DECISION DELEGATED TO HEAD OF PLANNING

Application No: H16-0526-25 **Applicant:** Mr S Brown

Proposal: Conversion of loft space into additional bedrooms, internal alterations, provision of conservation rooflights to west elevation and complete re-roofing and reinstatement of historic windows

Location: Monks House Bourne Road Spalding

02 | PROPOSED FIRST FLOOR PLAN
Scale 1:100

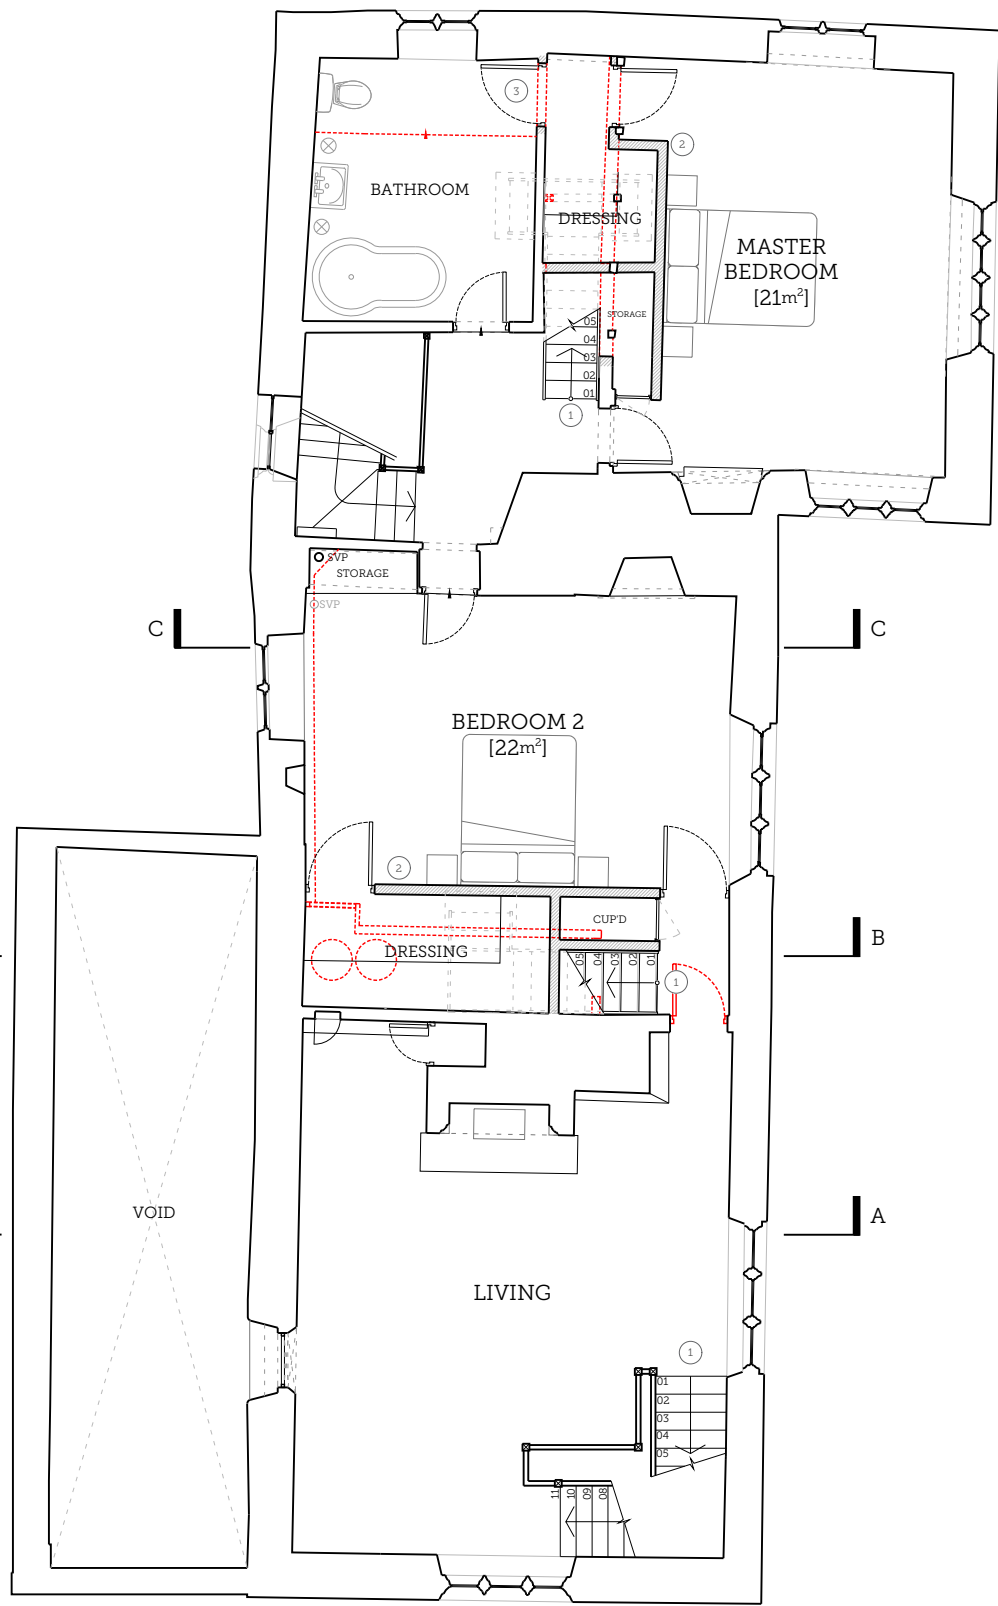
The application seeks to introduce three new staircases to facilitate loft access. As mentioned in our previous advice (of 22 April 2025) further detail is needed regarding proposed works to install the new staircases. The Heritage Impact Assessment states that 'the proposed adaptions to the first floor are relatively simple with seemingly no loss of historic fabric', however no details are provided. Without this detail, the installation of the three staircases has the potential to cause harm to the significance of the listed building. Detail should be provided of the proposed three new staircase installations to allow the LPA to properly assess potential impacts.

Monks House is a highly significant listed building. Proposed works therefore require a thoroughly informed Heritage Impact Assessment in a level of detail proportionate to the assets' importance. We previously advised that details of the proposed three new staircases should be provided to enable an adequate impact assessment. The Heritage Statement has not been updated, and the Impact Assessment section still does not adequately describe, or assess the impact of, proposed works. No further understanding is provided of works required to facilitate the new staircases and their impact on fabric at first and second floor.

Some section elevations of the proposed staircases have been provided, however the information is limited and of low digital quality, so much so that some annotations are illegible.

The proposed installation of three staircases seeks to substantially alter the interior of the GII* listed building. Any harm to a building of this significance requires clear and convincing justification. Without the appropriate justification, the proposal has the potential to cause harm.

additional bedroom accommodation. This could present a less harmful way of achieving further bedroom accommodation and reduce the number of new staircases required.

Was the entire floor between the first and second floors lost at the same time? We advise that the historical location is likely to be the most appropriate location for any new staircase. We advise that three staircases between the first and second floor appears excessive and lacks the justification required by NPPF paragraph 213. There are clearly impacts on all three first floor rooms from the introduction of these staircases, which is not explored sufficiently. It may be that the second floor can only practically accommodate two bedrooms rather than three. Whilst we accept the point that it would be a reasonable expectation for a house this size to have five bedrooms; there are three rooms with substantial volumes at first floor. Different occupants may use the Living Room as a bedroom - we do not believe there is an 'optimum viability' (NPPF, paragraph 215) argument here to support the introduction of three staircases.

The CBA are grateful to the applicants for the improved level of detail that now supports these proposals as well as the revised proposals for the second floor and reduced number of staircases that are now proposed. We are happy to defer to the expertise of your Conservation Officer in securing appropriate details to any permissions you are minded to grant.

At first, the internal alterations, proposing to install several new staircases were entirely unsupported by evidence. However, the applicant has now provided such evidence and has been able to support claims of historic staircases. Much of the layout alterations necessary effect only clearly later additions, likely added after the 1970s fire. Substantial alteration of the loftspace is required to create living spaces. However, clearly as a result of the fire, any layout of servants quarters has been lost, and there is little to no value in preserving the space as a bare loft, with exposed modern roofing materials, when we have evidential support for this space historically having been used as living space.

02 | PROPOSED LOFT PLAN

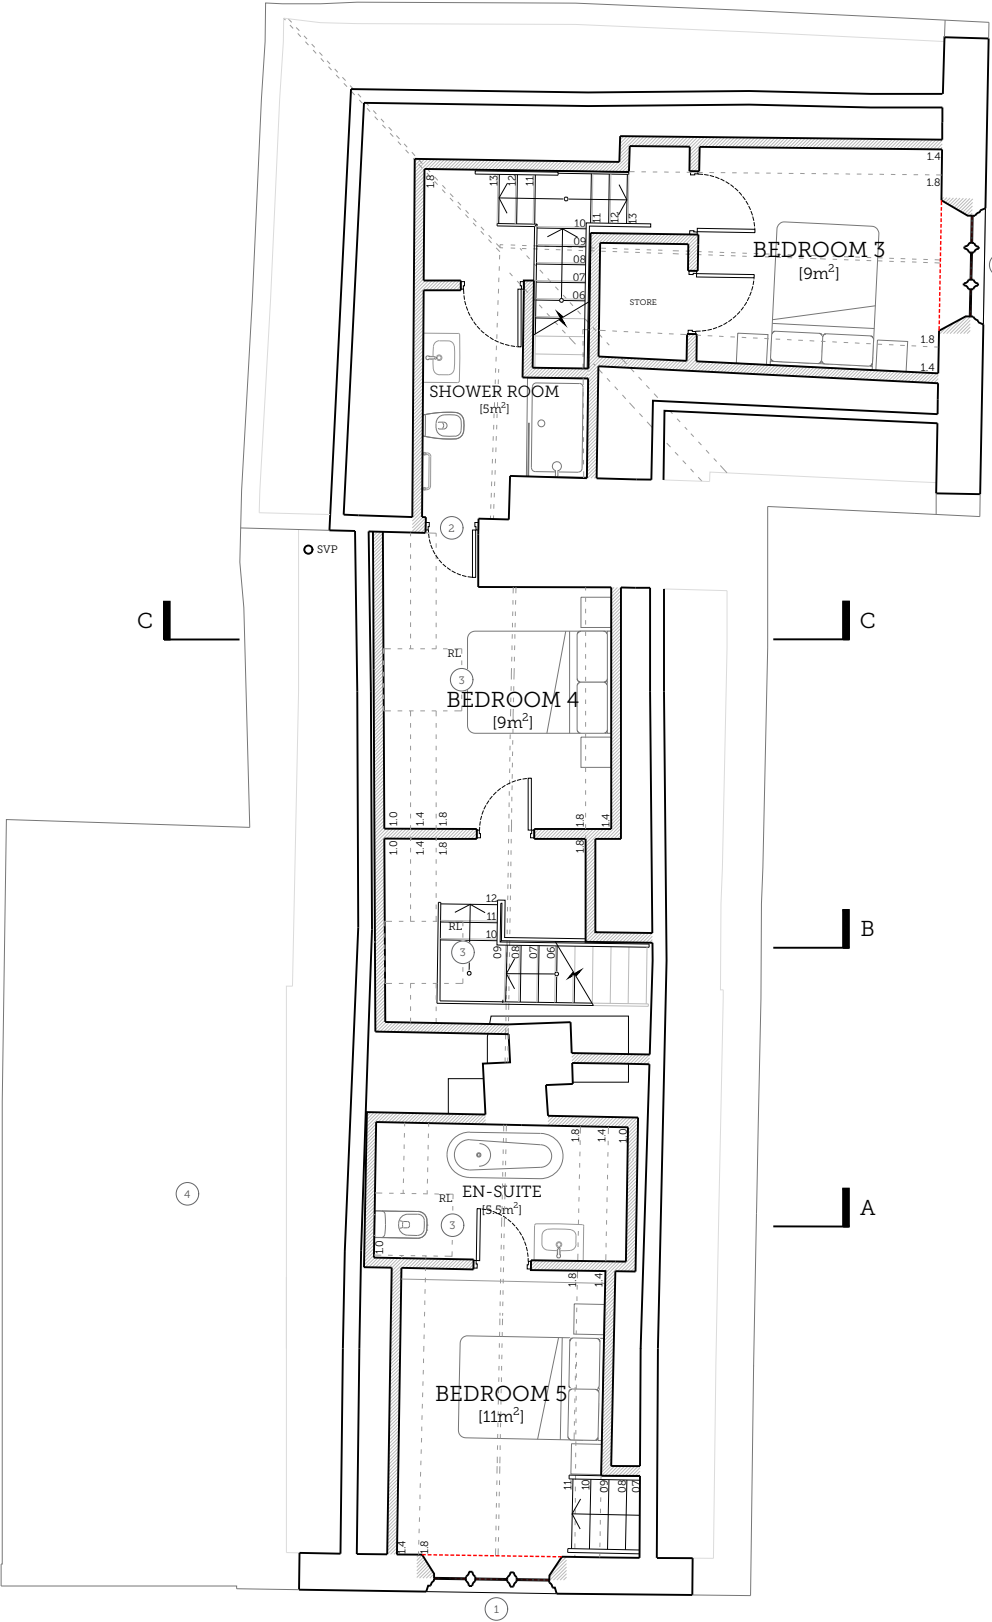
The application also seeks to install three rooflights to the west-facing roof slope. At present no details of the proposed rooflights have been provided, therefore they have the potential to cause harm to significance. Sufficient detail should be provided including the size, specification, material and colour of the proposed roof lights, in order to allow the LPA to make an informed impact assessment.

Similarly, the proposed re-roofing is positive, restoring handmade pegtiles to the span of the roof. The Historic illustrations of the site would appear to suggest a history of peg tiles over pan tiles. Moreover, the handmade finish should act as a means of improving the overall historic appearance of the site. However, to avoid risk of denuding the site of characterful roof undulations, I would suggest a condition requiring detail of the proposed underlay to be submitted and approved, with an emphasis on the proposed being as thin and as lightweight as possible. Some alterations to the roof structure are required for this work and for the installation of rooflights. However, none of the affected material pre-dates the 1970s fire, and so the loss is restricted to material of little to no historic value.

01 PROPOSED WEST ELEVATION
Scale 1:100

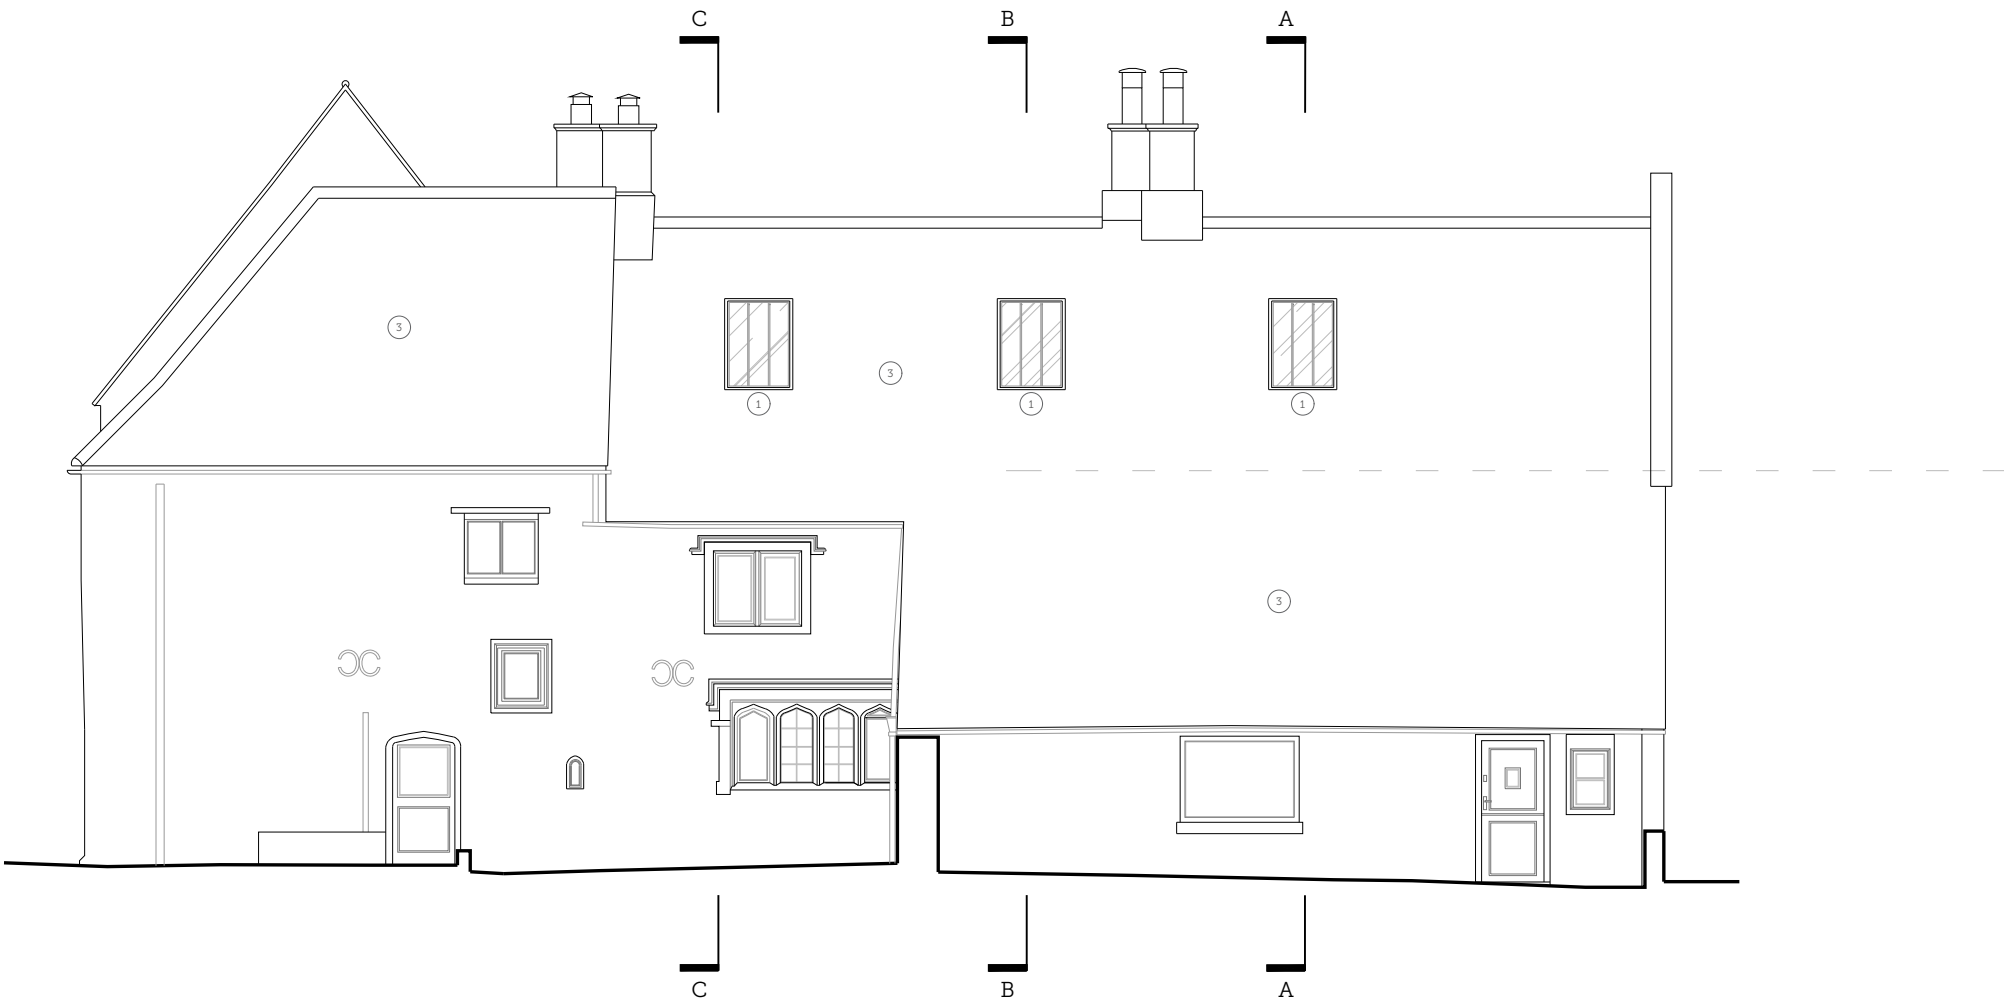
The installation of rooflights themselves is a form of harm, although ascribed as 'less than substantial' according to Para. 212 of the NPPF as well as the definition of harm provided by Para. 018 of the PPG. Per Para 213 of the NPPF, clear and convincing justification is required for such a form of harm, which I believe in this instance, is provided by the updated HIA. Para. 215 of the NPPF does require weighing of harm against the public benefit.

There is very little public benefit involved in this project as it is for works to a private residential property. However, Para. 215 does allow for public benefit to include the securing of an optimal viable use, and allowing some natural light into a roofspace which has been proven to historically contain living quarters, I think can be used to justify a public benefit in the form of securing a viable use for this space - this is especially the case given the overall extremely low amount of actual harm I suggest to be caused by this proposal.

02 | PROPOSED GARRET WINDOW (SOUTH)
Scale 1:20

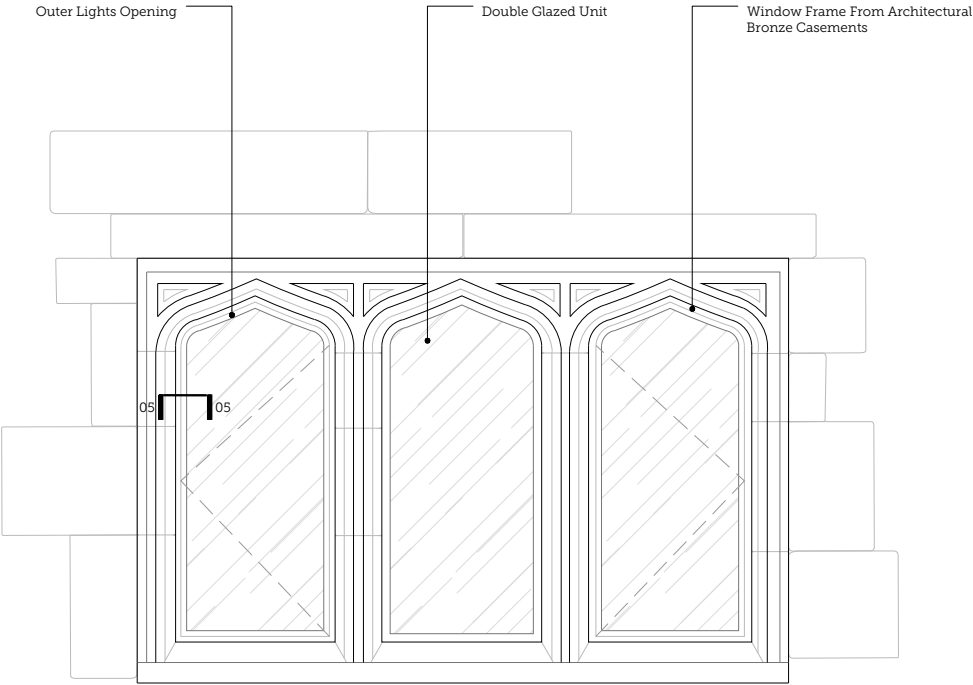
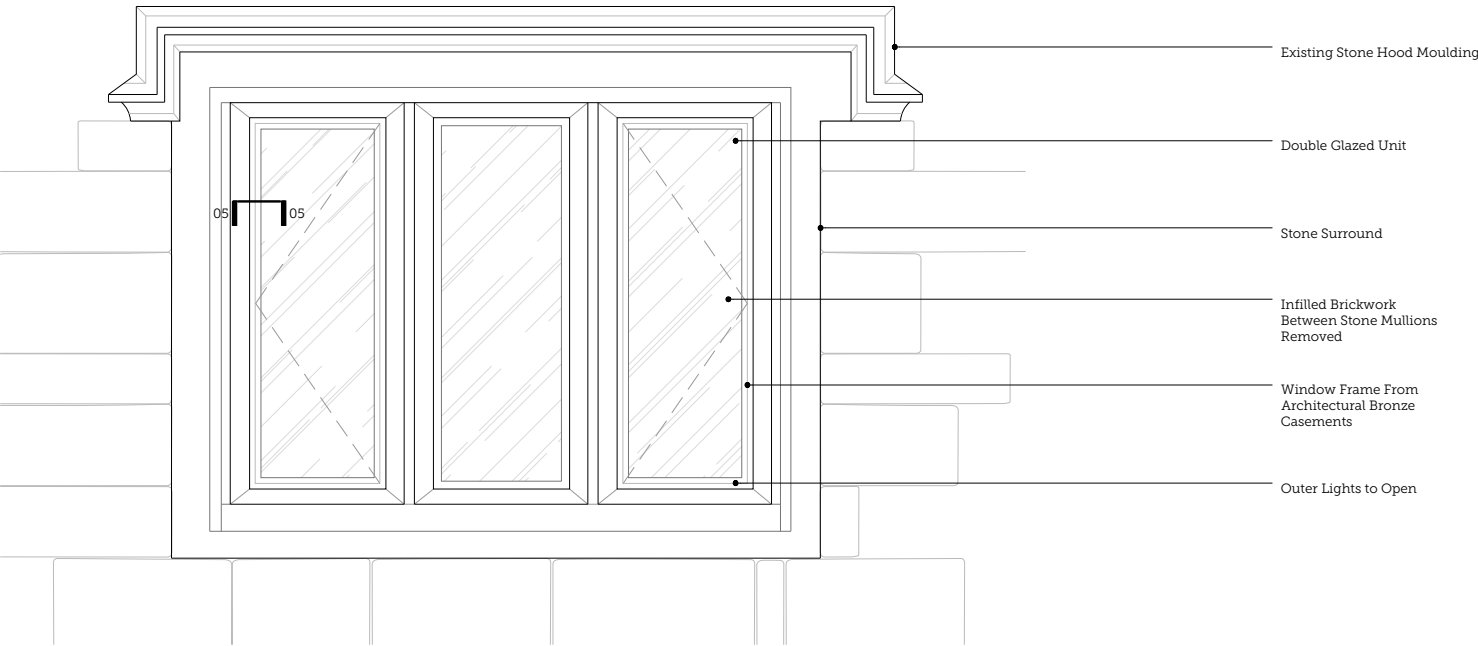
We welcome the proposed works to introduce a breathable membrane to the roof structure and a roof coving that is more sympathetic to the building. We also welcome the reinstatement of both second-floor mullioned windows, subject to your Conservation Officer being content these works are suitably detailed.

Firstly, it is imperative to state that the reinstatement of glazing to the external mullion windows lost in the fire during the late C20th is an unequivocal positive aspect. Whilst they are proposed of double glazed format, the frames as extant have been bricked-in, and therefore there is no value in existing frames for there to be an argument based on retention of single glazing.

"Thank you for consulting us on this. The submitted, revised Heritage Impact Assessment meets the required standards. Furthermore, the proposed alterations represent a positive impact; for example, the reinstatement of mullion windows. We therefore raise no objection to Amendment 2: Amended Heritage Impact Statement & Plans"
